Project Name and Address
WHITE COTTAGE FARM
16910 THOMPSON RD
COLORADO SPRINGS, CO 80908
OWNER: SHAWNA SCHOTANUS
TAX SCHEDULE NUMBER: 51190-00-007
FILING: 51190 000 07
ZONING: RR-5

Project
SITE DEVELOPMENT & LANDSCAPE PLAN
Date
6/7/2021
Scale
1/32" = 1'-0"
SHEET SIZE: 24x36

Sheet
L102

Project SITE DEVELOPMENT & LANDSCAPE PLAN	Sheet L102
Date 6/7/2021	
Scale 1/32" = 1'-0"	
PAPER SIZE: 24x36

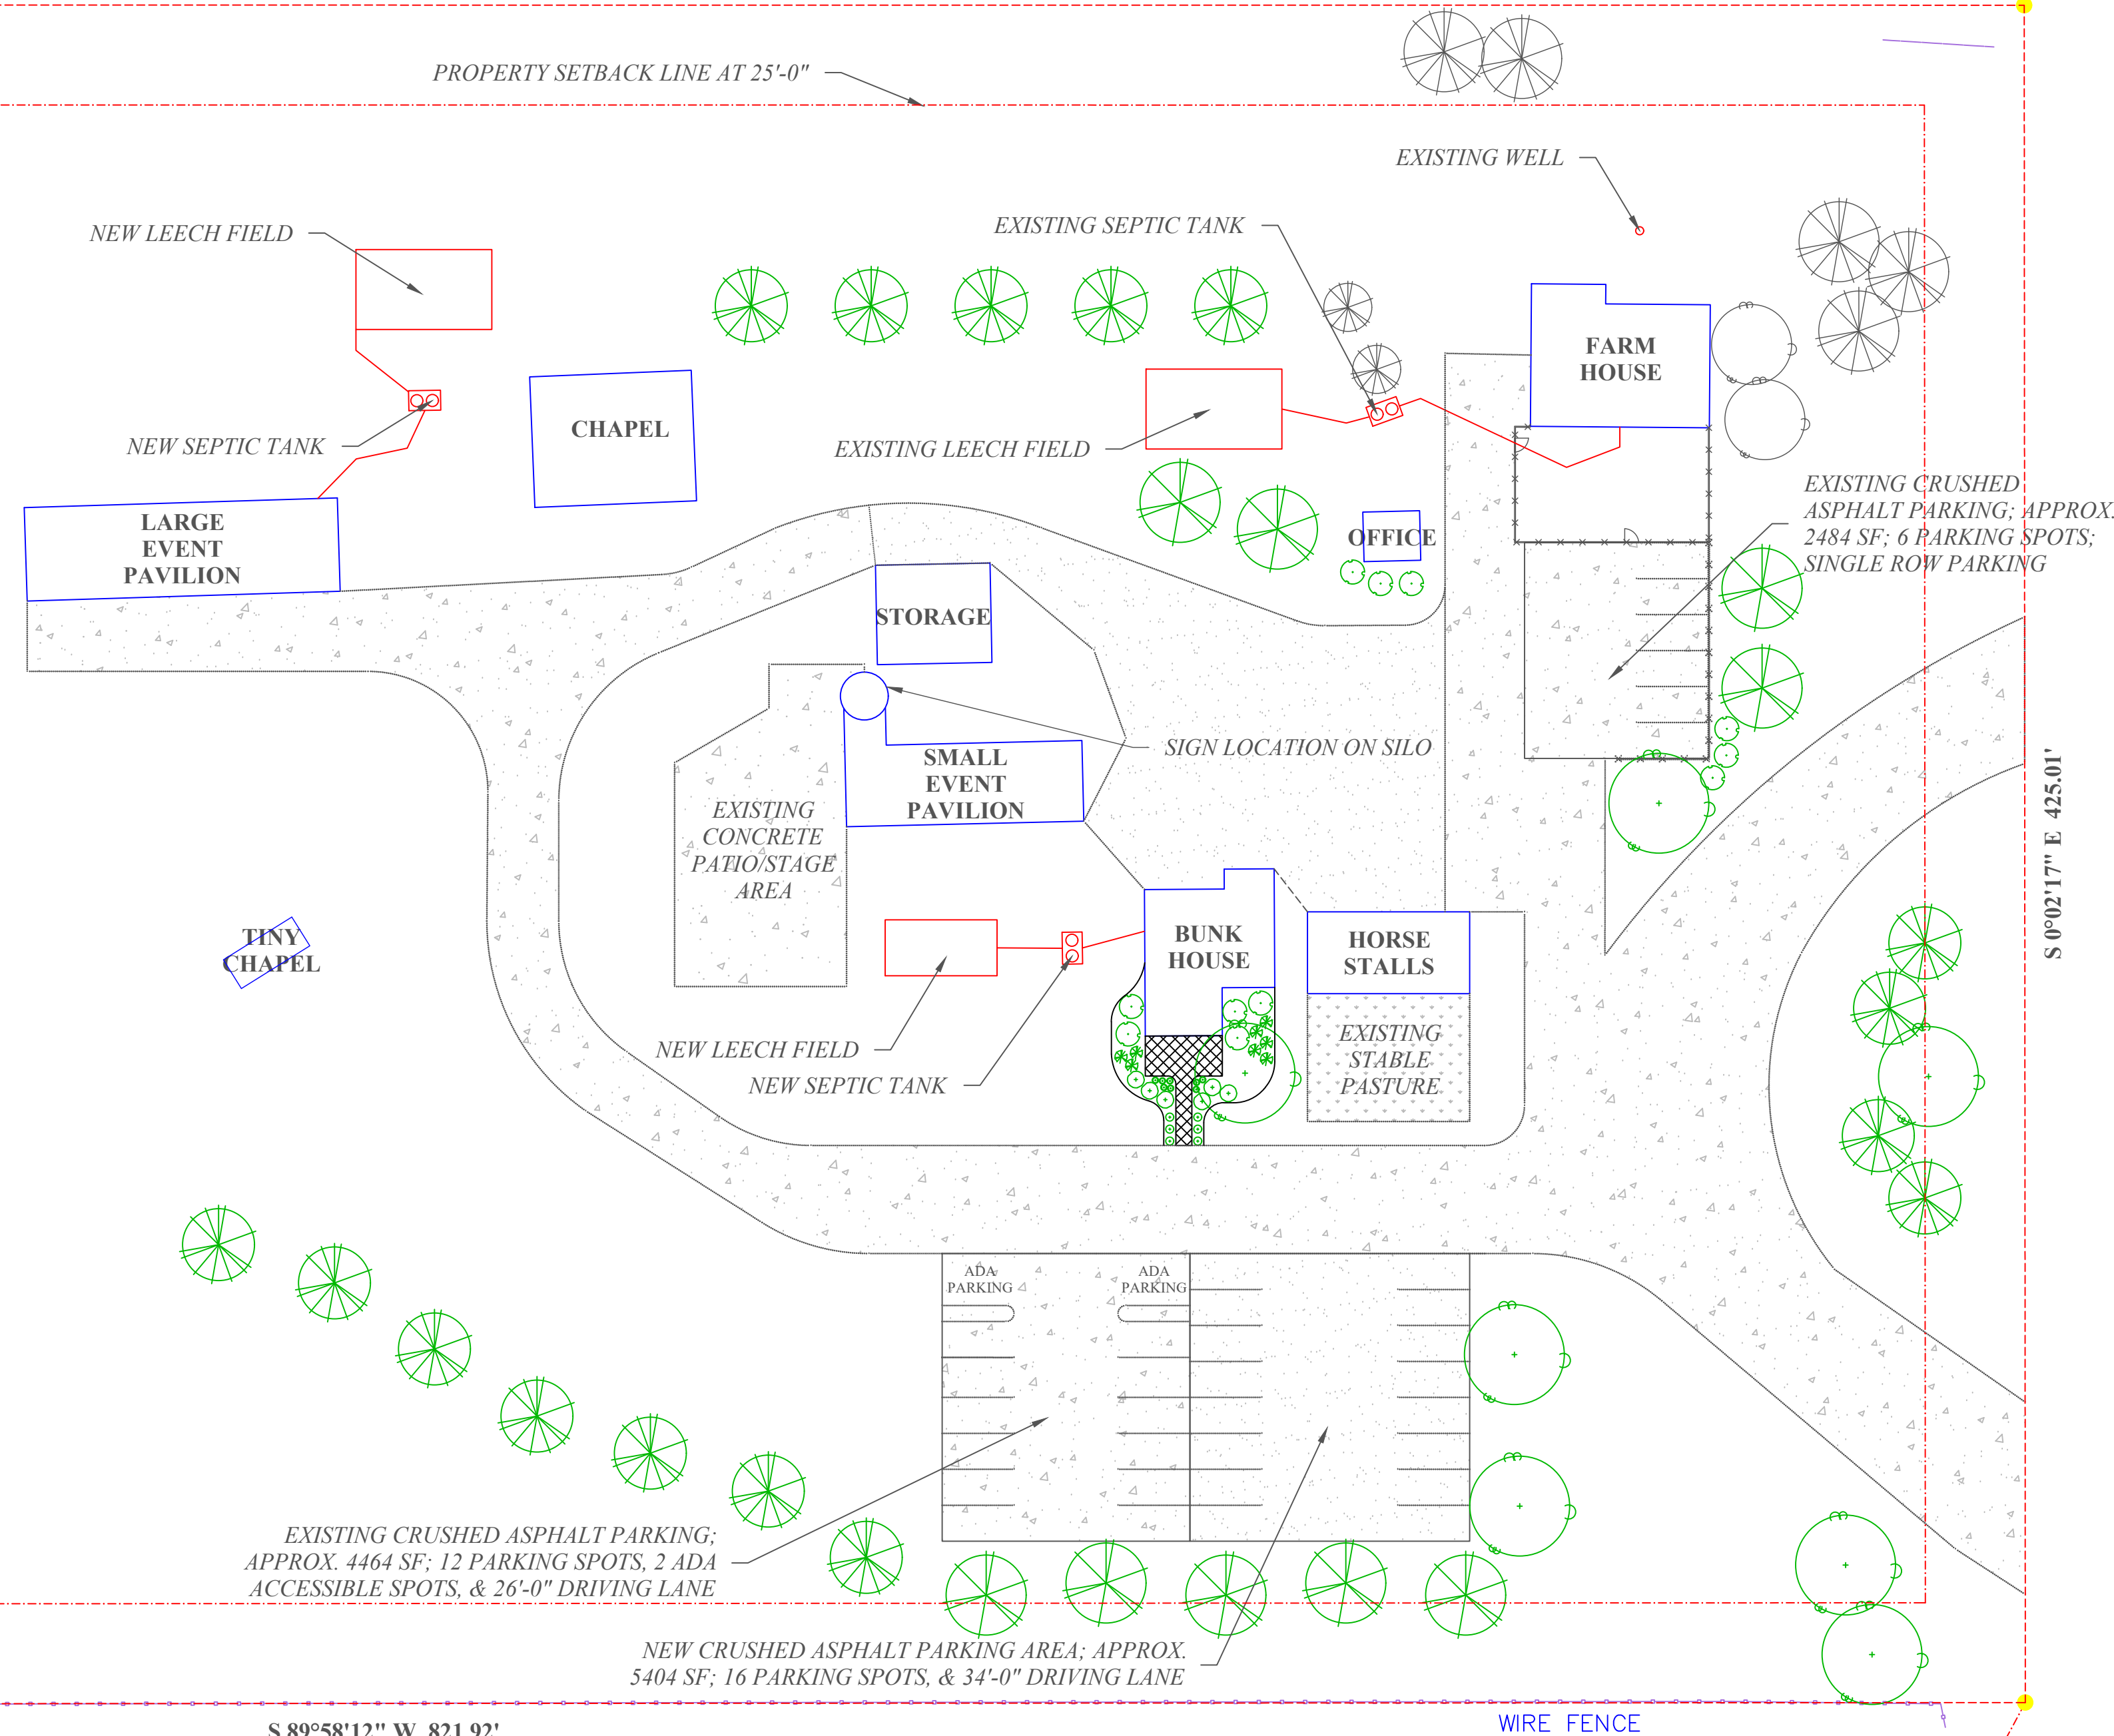
Summary table or notes shall include the following:

Provide a 1x2 inch signature block for the PCD Director to sign.

Per traffic memo submitted with this application, driveway access point shall be aligned at 90 degrees to Thompson Road. Please reconfigure driveway access point to align at 90 degrees to Thompson Road. Driveway shall also be compliant with the ECM criteria regarding commercial driveway grades, which should be a maximum of 4%. A deviation request can be submitted for review but does not guarantee approval.

Please update site development plan to show existing and proposed contours (2 ft contours). Please make sure to label any major drainage ways that travel through the parcel. Also, show building floor elevations for both proposed and existing.

Please label Thompson Road.

There are no driveway permits on file. Please apply for driveway permit by contacting Petra Rangel at petrarangel@elpasoco.com

The building footprint for all structures need to be depicted and labeled to include the proposed use(s), floor area, and height. The setbacks of all building footprints dimensioned from all property lines need to be shown.

No ADA spaces have been identified. Will there be any ADA spaces?

Please show existing and proposed easements.

Please add "PCD File No. PPR-21-028" to the bottom right corner.

Please label scale dimension.
